From: Janina Cooper [REDACTED]
Sent: 28 April 2021 11:10
To: Finlay Gardner <Finlay.Gardner@arun.gov.uk>; Planning <Planning@arun.gov.uk>
Cc: David Cooper [REDACTED]
Subject: OBJECTION - BR/93/21/PL Planning at 22 Neville Road PO22 8BN

The proposed development seeks to construct a single storey dwelling to the rear of the existing dwelling at 22 Neville Road, Bognor Regis. The host dwelling itself is split into two flats, at ground floor and first floor level. The proposal details one parking space adjacent to the construction of the dwelling, and soft landscaping along the Northern and Eastern boundaries of the application site.

Component: **Proposed Ground Floor Plan**

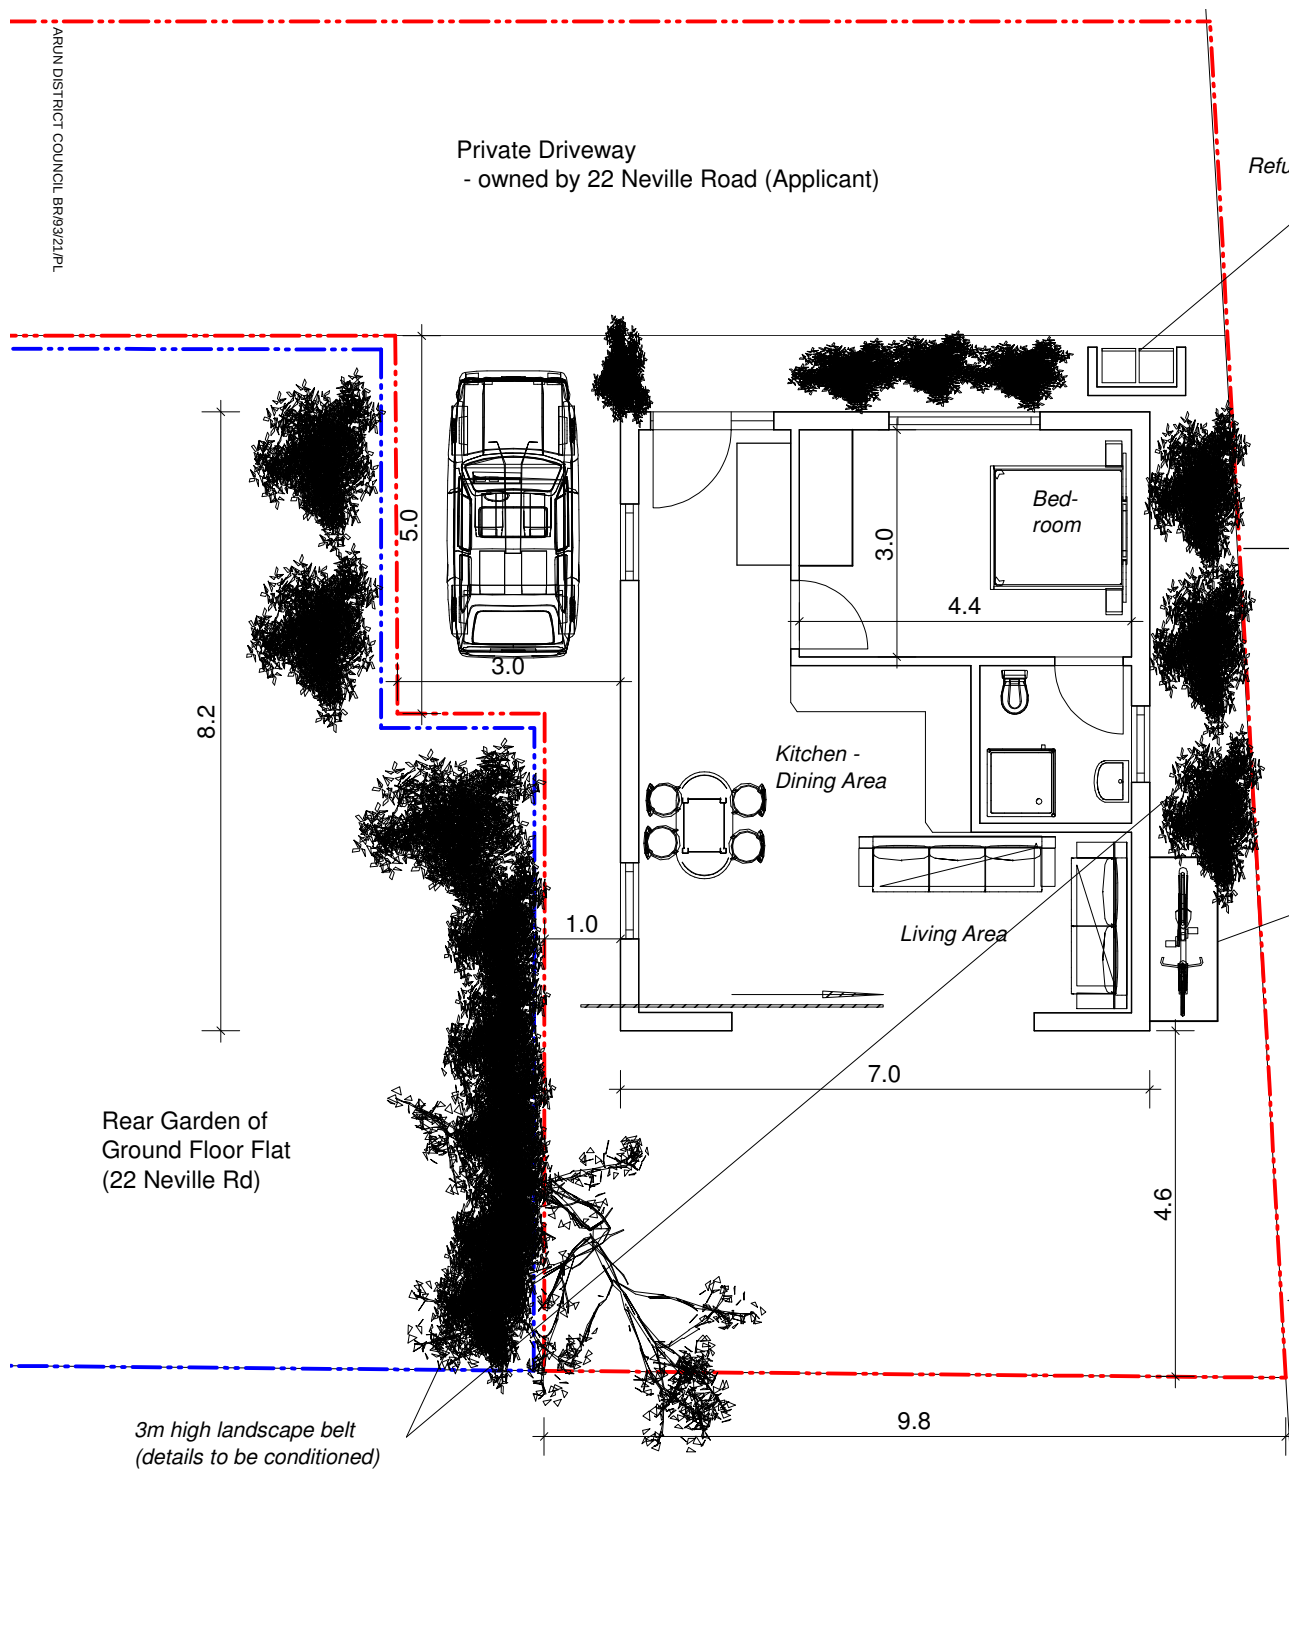
The dwelling would be positioned close to the boundaries of the site, this is due to the contrived nature of the proposed site, as it relates to the removal of an area currently used as a residential garden for the occupiers of the existing flats. The dwelling is sited approximately 1m from these boundaries respectively, which although allows space for access to the rear (for bike storage), this constrains the proposed dwelling and looks visually at odds with the nature of similar plots within the locality which exist for parking or as residential gardens.

Having regard to the existing character and layout of the area, it is considered that the proposal would have a constrained and cramped appearance not in keeping with the established layout and pattern of development failing to integrate with its surroundings and thereby harming the character of the locality.

The site and this proposal would provide an inadequate living environment for future occupiers. While it has adequate amenity space in the rear garden, the dwelling would be sited to the rear of a terrace of flats, with separate dwellings (due to the flat uses) at ground floor level. Furthermore, the dwelling itself would be considerably set back from the street scene, giving it a contained/hemmed in feeling for prospective occupiers. Also vehicle comings and goings would add to this unsuitable surrounding living environment.

The access land to this property, whilst it is noted that it is an existing access, intensification of the use of this access should be avoided where possible, especially give the pedestrian access use of this walkway (for occupiers). It is considered that the intensification of the use of the access, whilst it may not give rise to any potential highway impact, is considered to exacerbate the inappropriate living conditions of neighbouring dwellings.
